The Planning Inspectorate  
3/18 Eagle Wing  
Temple Quay House  
2, The Square  
Bristol  
BS1 6PN

9<sup>th</sup> June 2015

***A14 Cambridge to Huntingdon Improvement Scheme  
Written submission (ID: 10030592) detailing essential changes to the  
application that we recommend be included as formal conditions  
of any development consent order***

Drawing file: TR010018 / TR010018-004540-ENGINEERING SECTIONS BUCKDEN ROAD SHEET 18 OF 59 REGULATIONS 5(2)(o) & (p) & 6(2).pdf

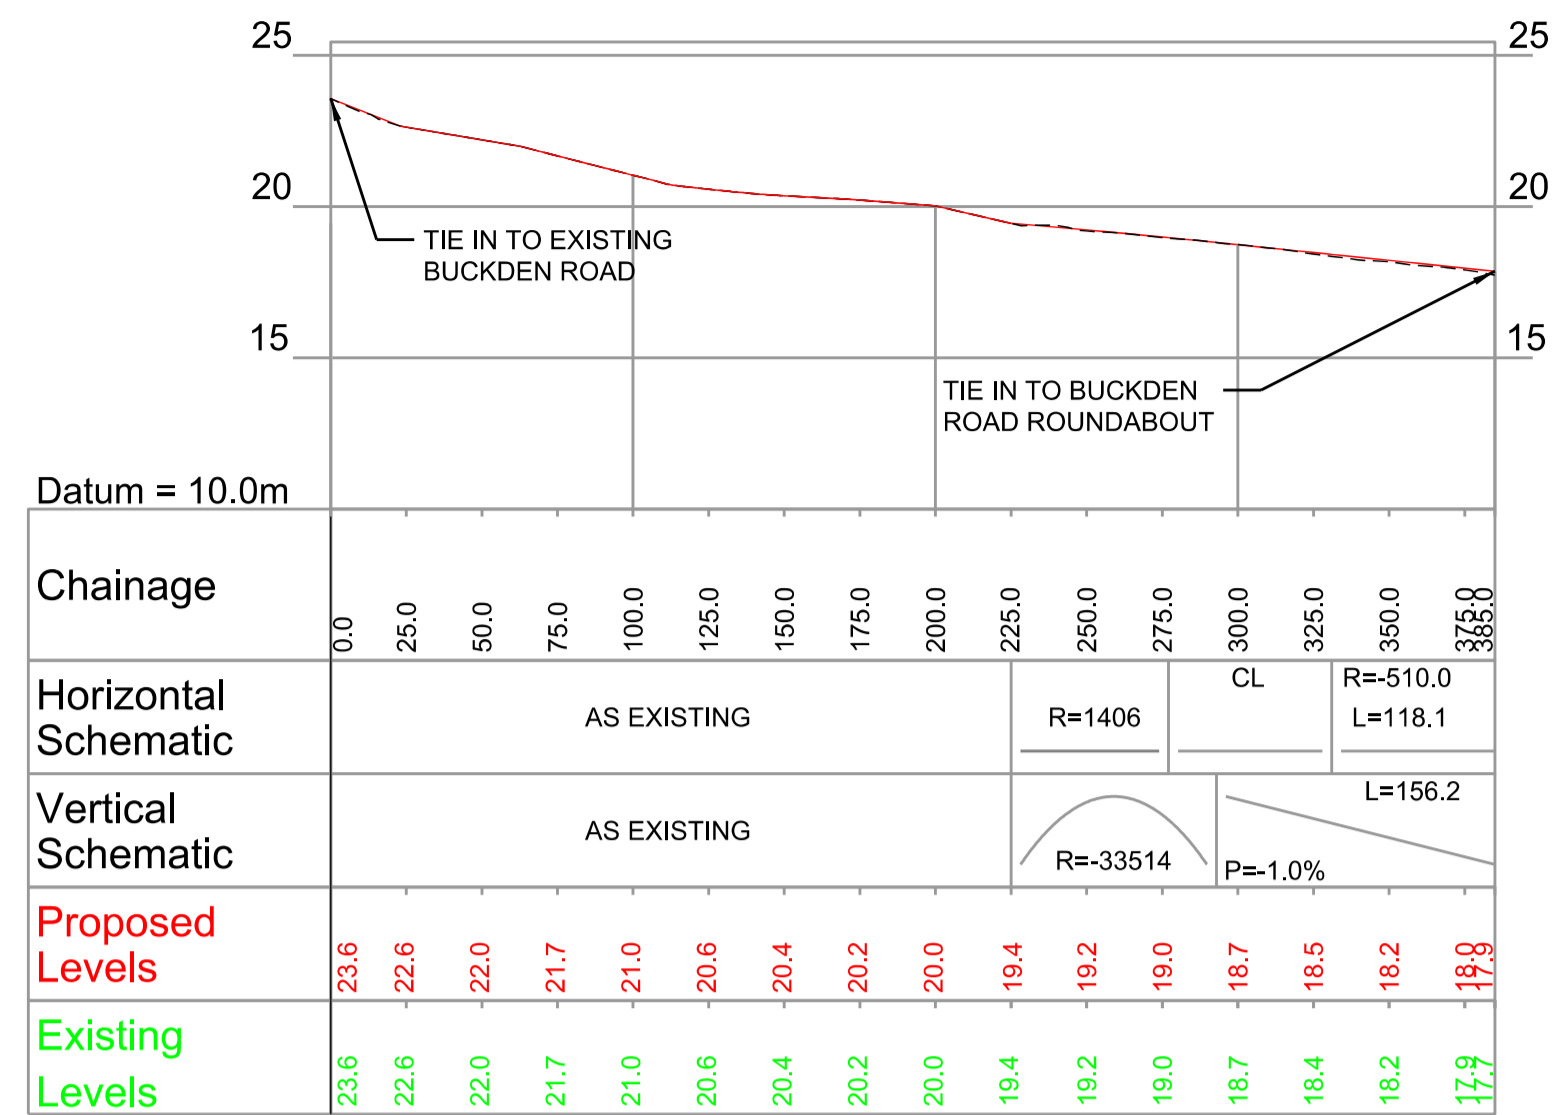
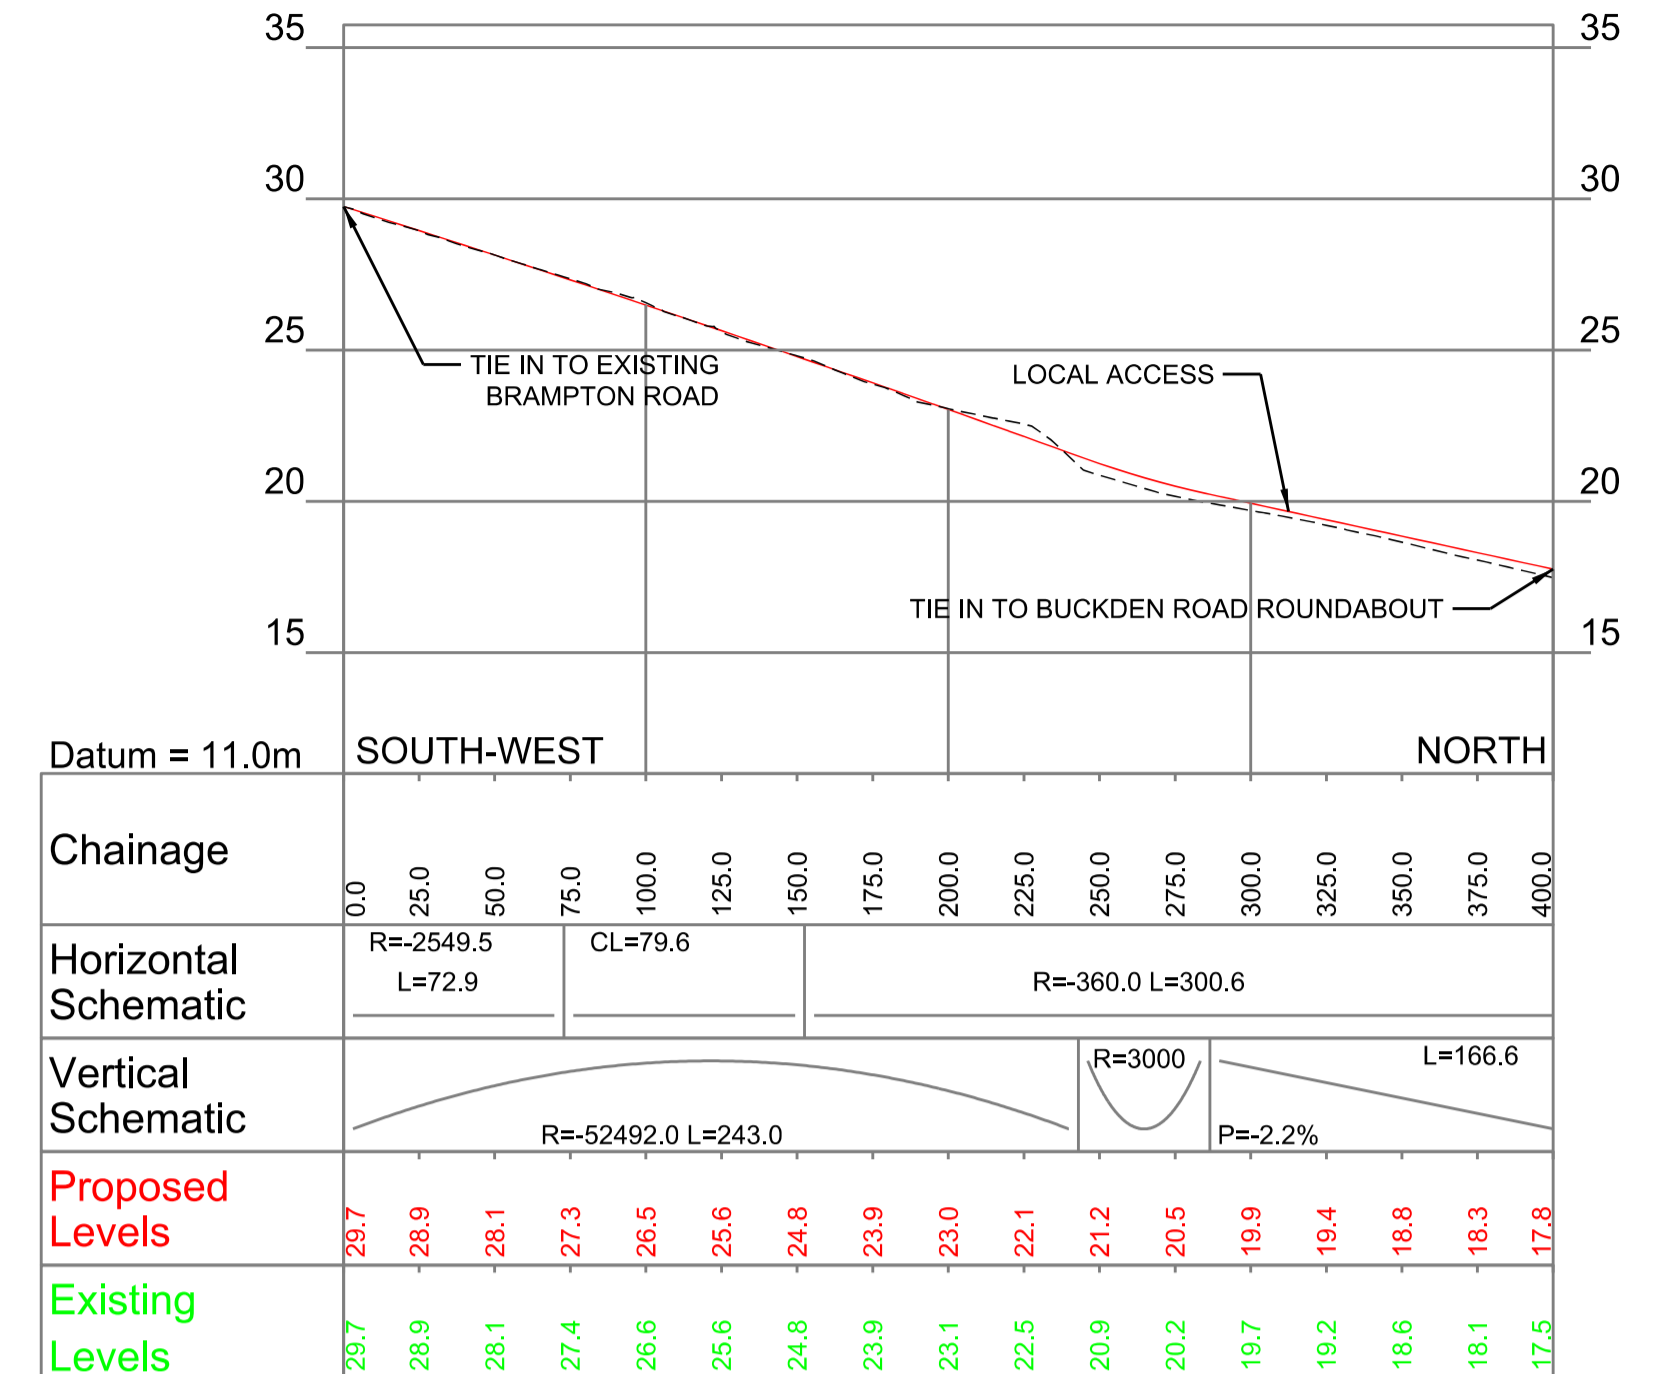
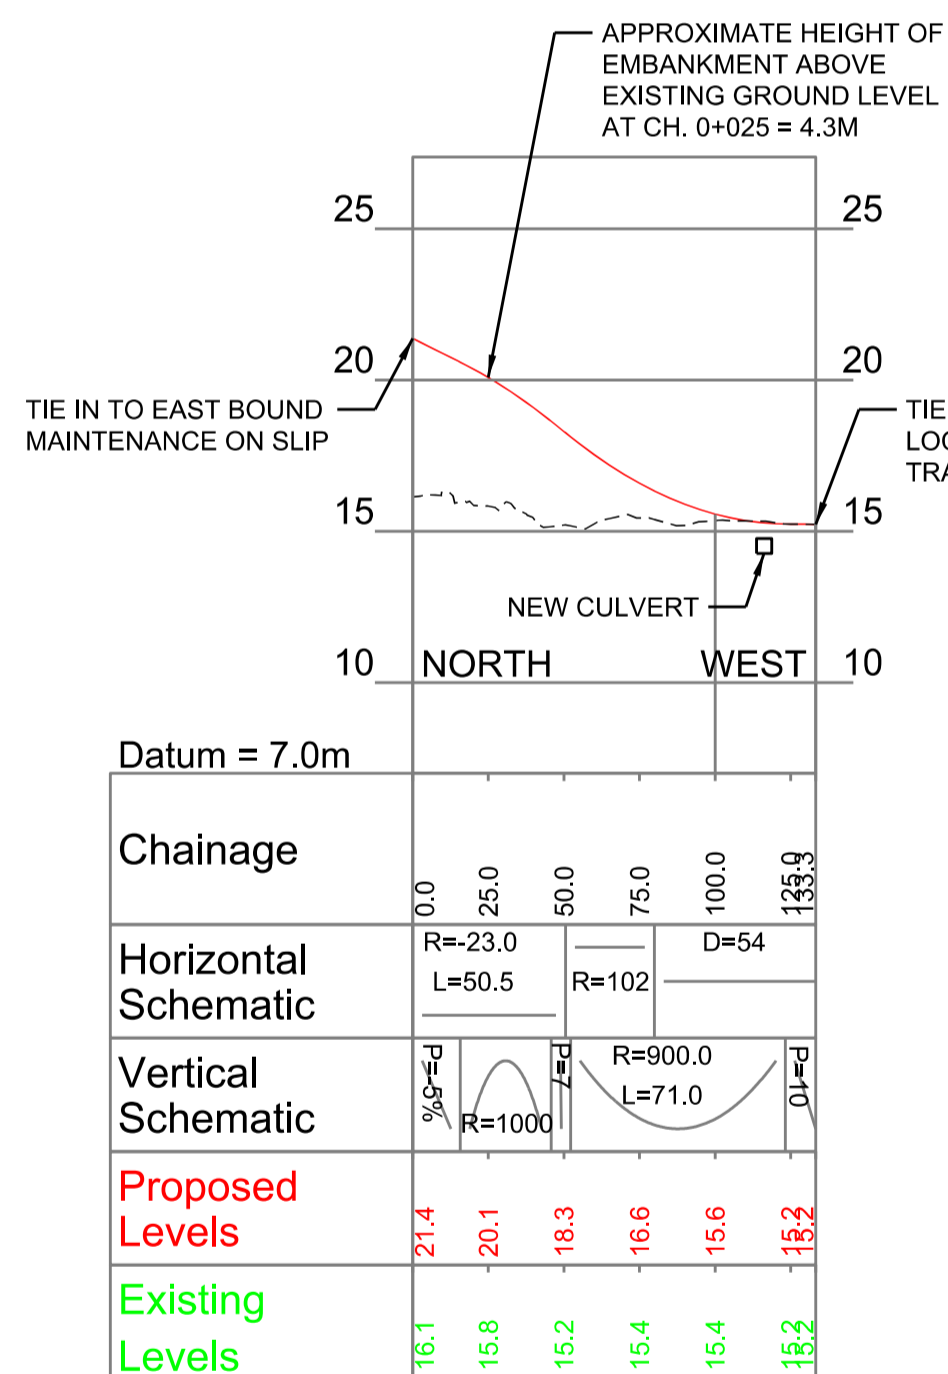
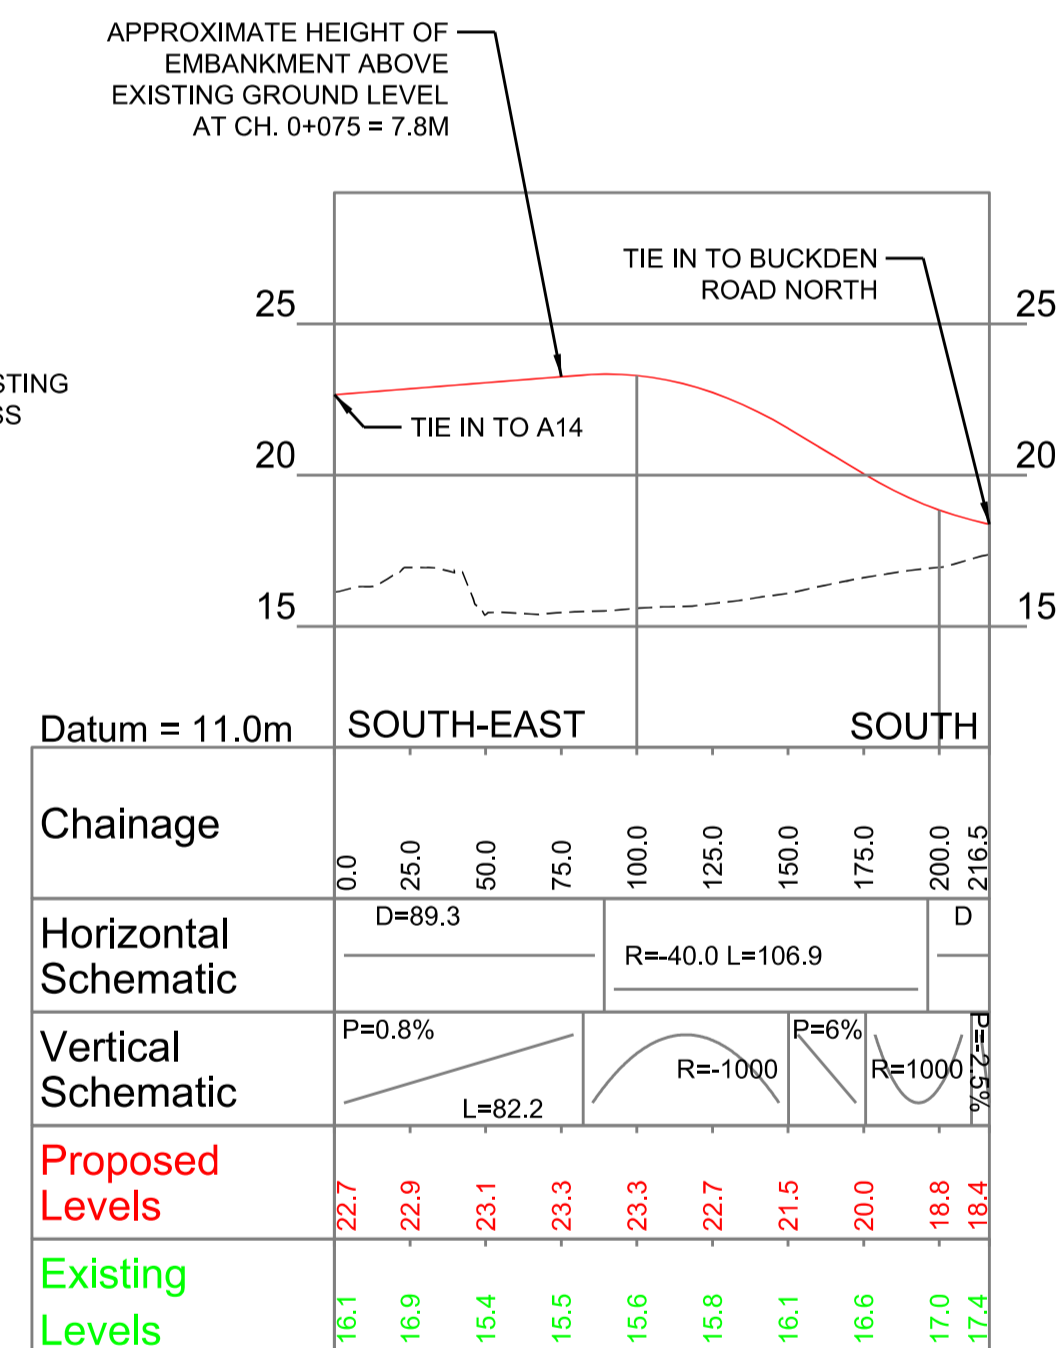
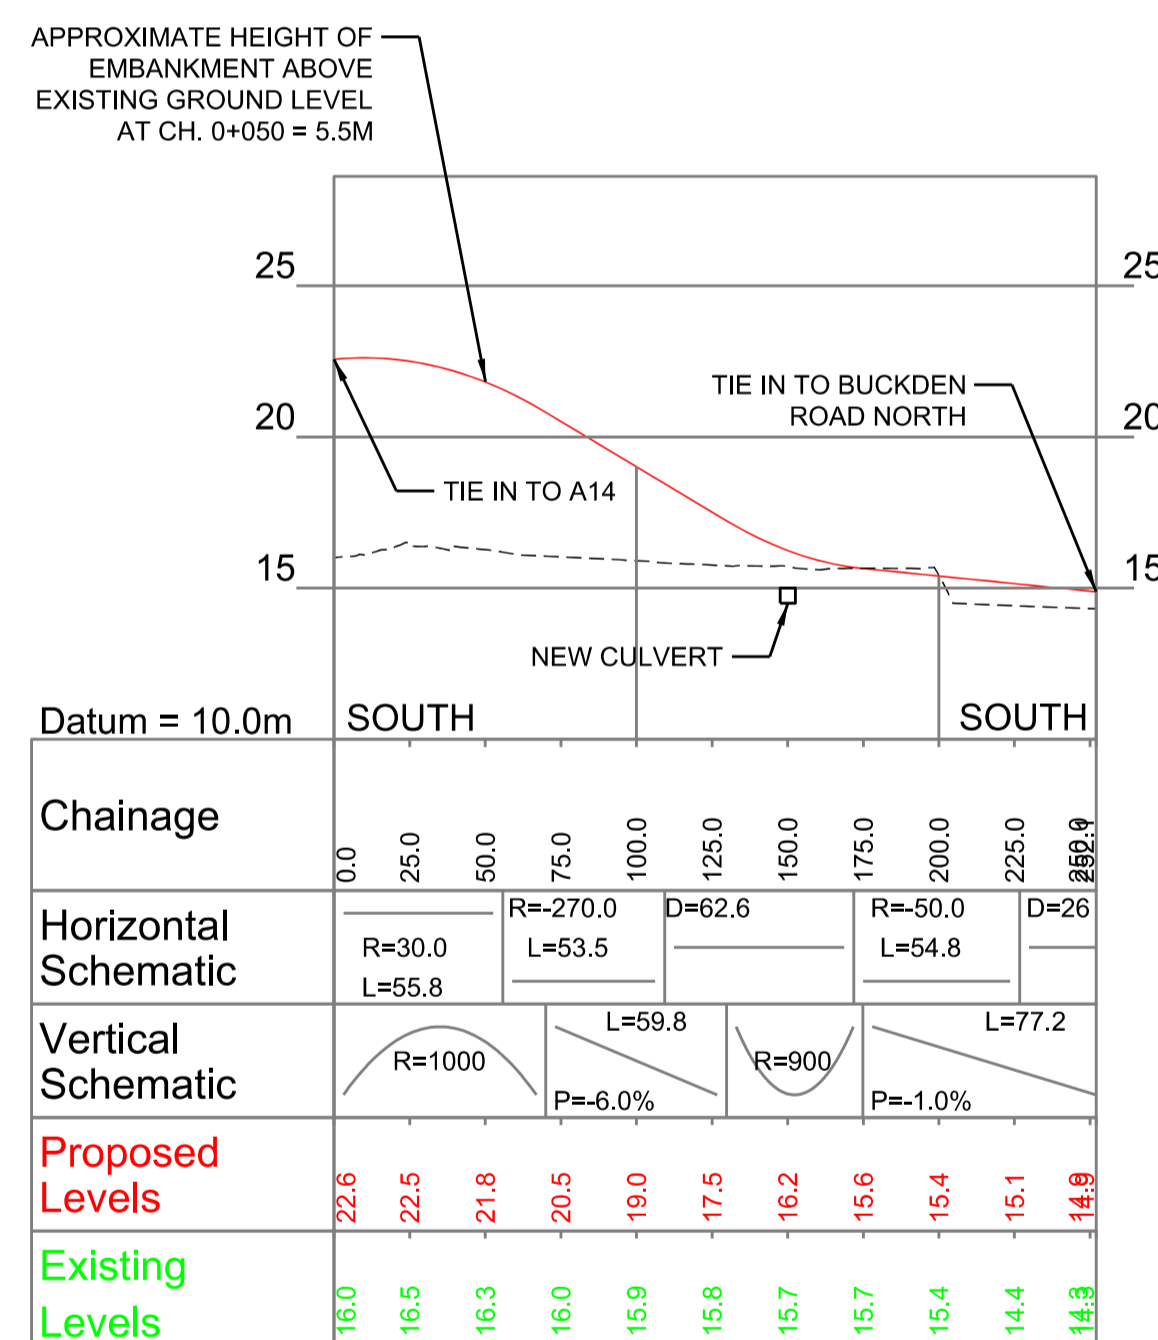
The revised plans show the creation of new cyclepaths alongside the realigned roads north of Buckden (specifically alongside Brampton Road and alongside Buckden Road/B1514). The plans also show a surfaced byway from the A1 access road across to Grafham Road. These are welcome proposals that reflect the existing need for better NMU routes in this location. But the proposals need to be more detailed and/or expanded to create a fully connected set of NMU routes. The following details should be added or confirmed:

- The new NMU paths alongside Brampton Road and alongside Buckden Road/B1514 should be at least 2.5m wide.
- The plans state that the “Byway will be improved as required to be fit for use by vehicles”. It is not clear what is intended for this Byway. The proposed resurfacing of the Byway is a desirable upgrade that should be designed to provide a long term surface for use by all NMUs. If the surface is designed for use by motor vehicles, this should only be for a short term use to support the construction of the new A14 and when the construction is complete the Byway should be restricted to NMU use only.

- The plans should be extended to include an NMU connection to Buckden village. There is an existing path on the east side of the A1 and this should be upgraded to a minimum width of 2.5m to provide a higher quality connection between the new NMU path alongside Brampton Road and Buckden village.
